Helios
Ham Manor Way
Angmering
West Sussex
BN16 4JQ

23/10/2017

A/176/17/PL

I am writing to object to the planning application A/176/17/PL, two detached dwellings 9th, Ham Manor Way. My objection are listed below.

Site Plan (1:200)

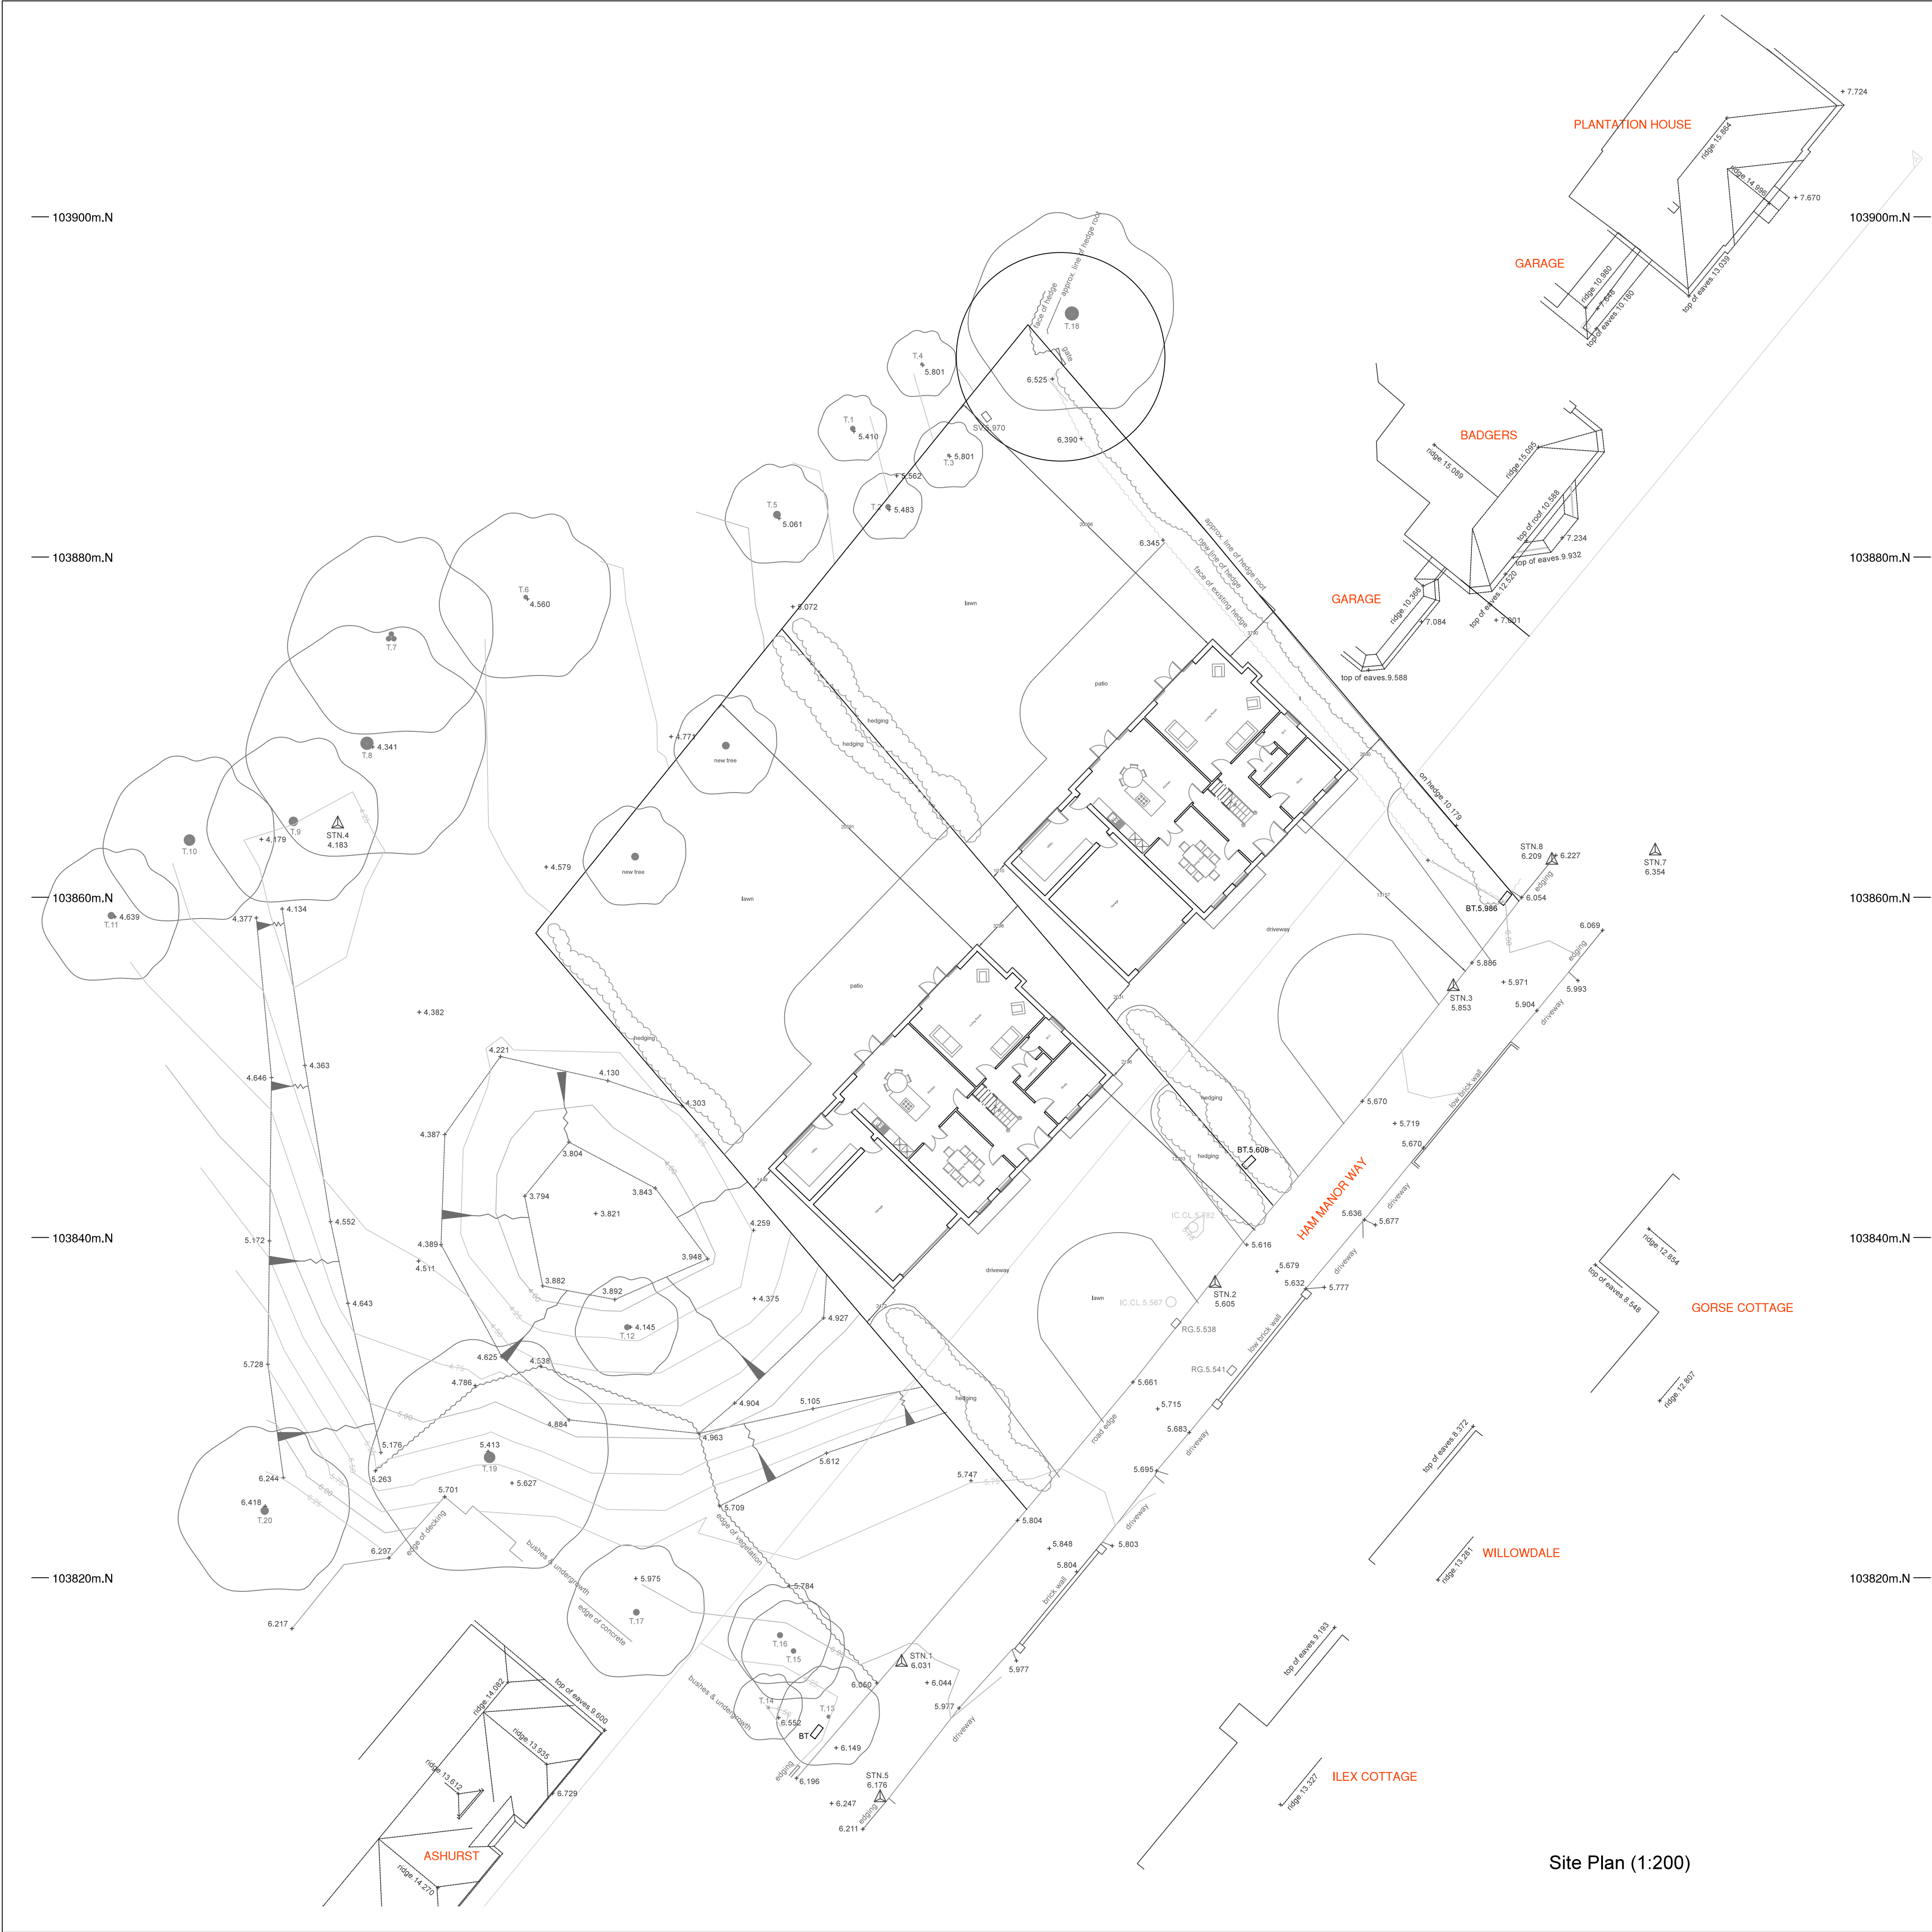
- HMW is also a public footpath. For Angmering residents the area in question is of community value, especially considering the number of people using the footpath for access, recreation and admiration of the Historic Parkscape. HMW is a narrow road with no pavements, pedestrians have to step off the road onto adjoining land or gaps to avoid reversing lorries since the road has no turning points. Having the proposed development adjacent to the public footpath, not only poses a Health and Safety risk during construction, but the proposal for 12 car spaces will increases the Health and safety issue on HMW.

Street Elevation (1:200)

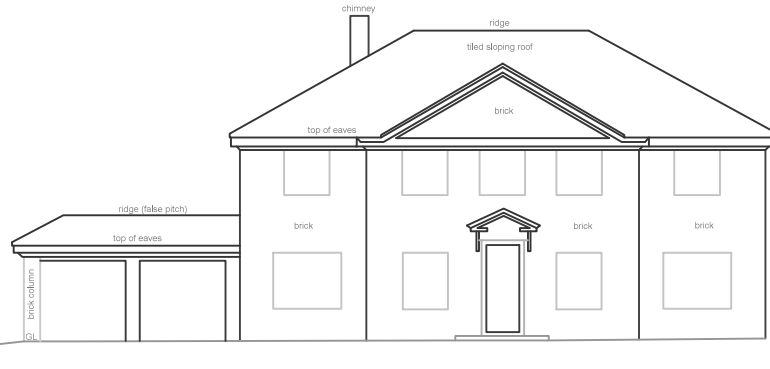
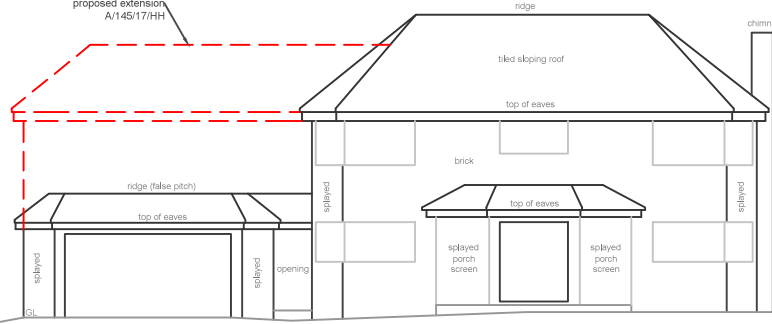
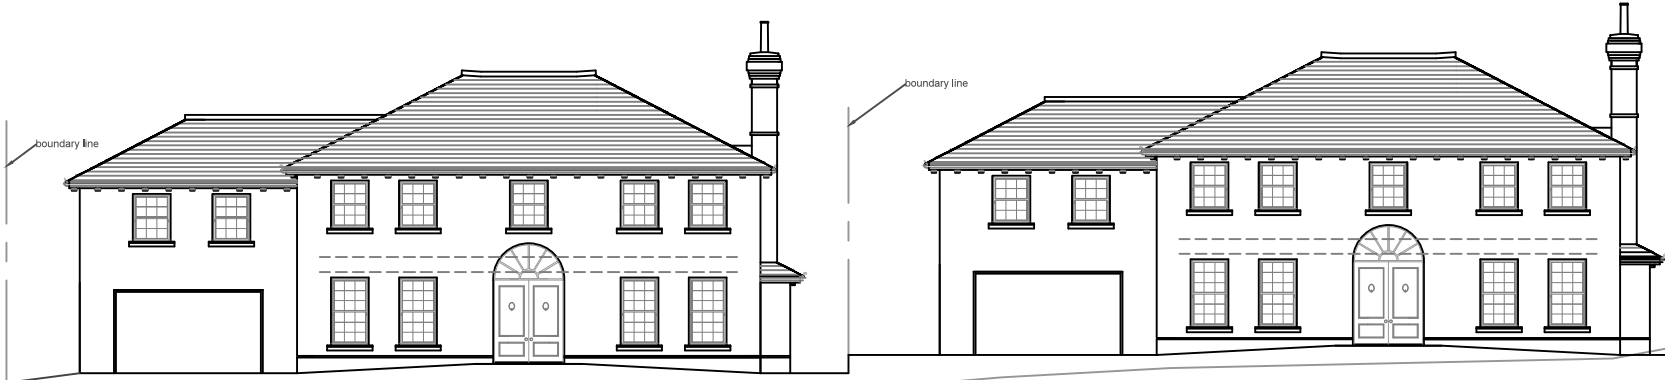
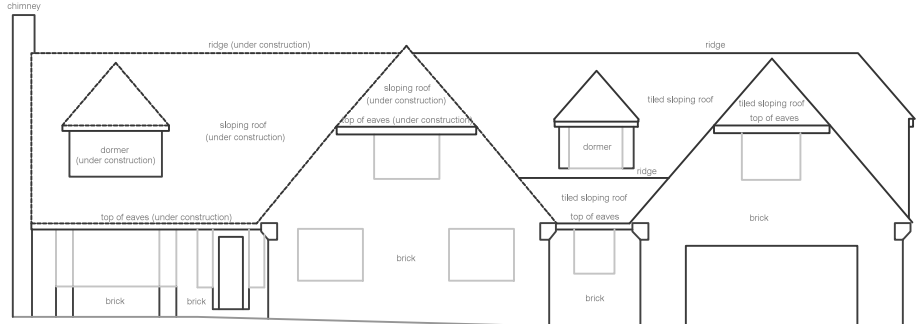
- Being big houses on small width plots will result in no spaces in between each property (Street Scene). This would take light for some windows of "Badgers" located to the north of the development.
